SUBMISSION TO AN COIMISIÚN PLEANÁLA

Re: Littleton Wind Farm Strategic Infrastructure Development Application

Case Reference: PAX92.324370

Submission by: Robert Rafter

<b>TITLE:</b>	
Key Habitat Area 4: Lanespark Bog	
<b>PROJECT:</b>	
Littleton Wind Farm	
<b>FIGURE NO:</b>	7.5
<b>CLIENT:</b>	Littleton Wind Farm DAC
<b>SCALE:</b> 1:5,500	<b>REVISION:</b> 0
<b>DATE:</b> 18/03/2026	<b>PAGE SIZE:</b> A3

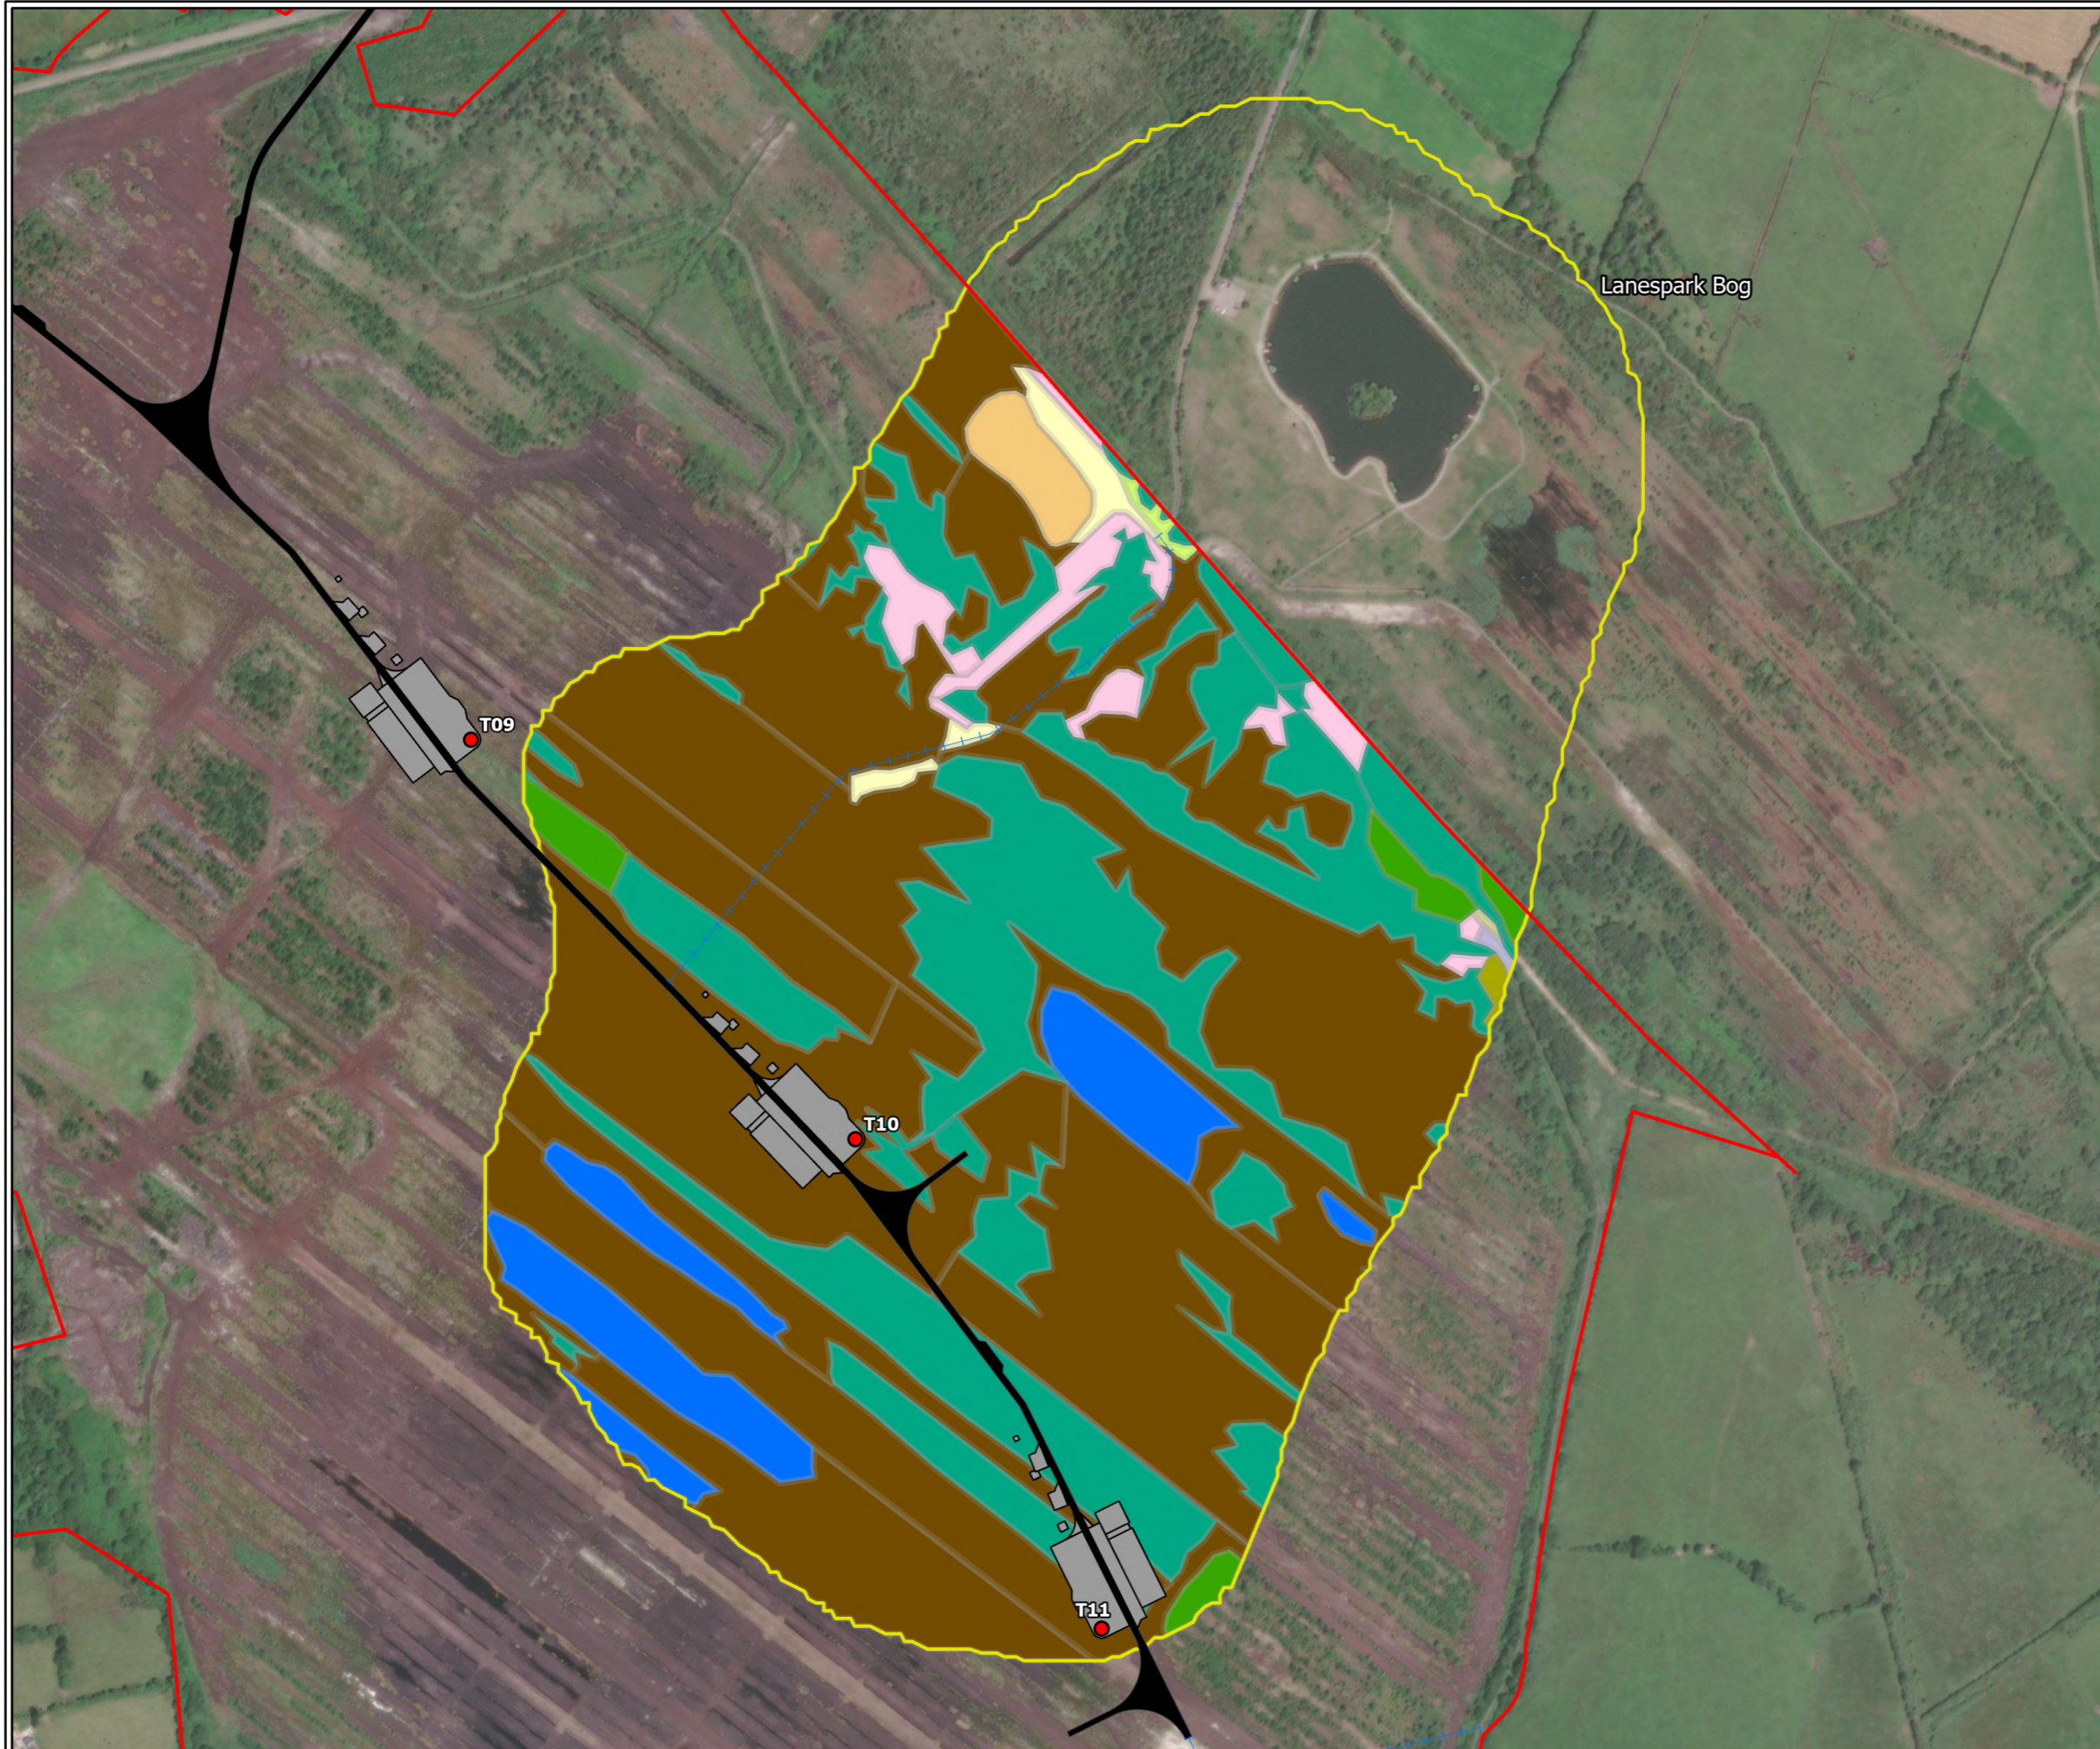
The 2025 Ballybeg/Lanespark/Derryvella rehabilitation documentation indicates that Lanespark was mapped as a constraint because it is included within the proposed Littleton Wind Farm footprint, with only Ballybeg and Derryvella considered for Phase 2 enhanced rehabilitation (Bord na Móna, 2025). That creates an important baseline question for the Commission: whether Lanespark's Phase 1 rehabilitated condition should be treated as the complete future baseline, or whether the proposed wind-farm land use has limited the rehabilitation trajectory being presented and assessed.

The 2025 rehabilitation plan shows that Lanespark was not excluded from Phase 2 because it had been transparently assessed and found unsuitable for enhanced rehabilitation. Rather, the available documentation records Lanespark as a constraint because it lies within the proposed Littleton Wind Farm footprint, with only Ballybeg and Derryvella considered for Phase 2 enhanced measures (Bord na Móna, 2025).

That distinction matters. If Lanespark was excluded from Phase 2 because of a land-use decision associated with the proposed wind farm, then the EIAR should not simply rely on the Phase 1 condition as though it were an environmentally inevitable endpoint. The proper question is not whether Lanespark was rehabilitated at all. It was. The proper question is whether the EIAR has adequately explained the rehabilitation trajectory that is being relied upon, limited or displaced by the proposed wind-farm layout.
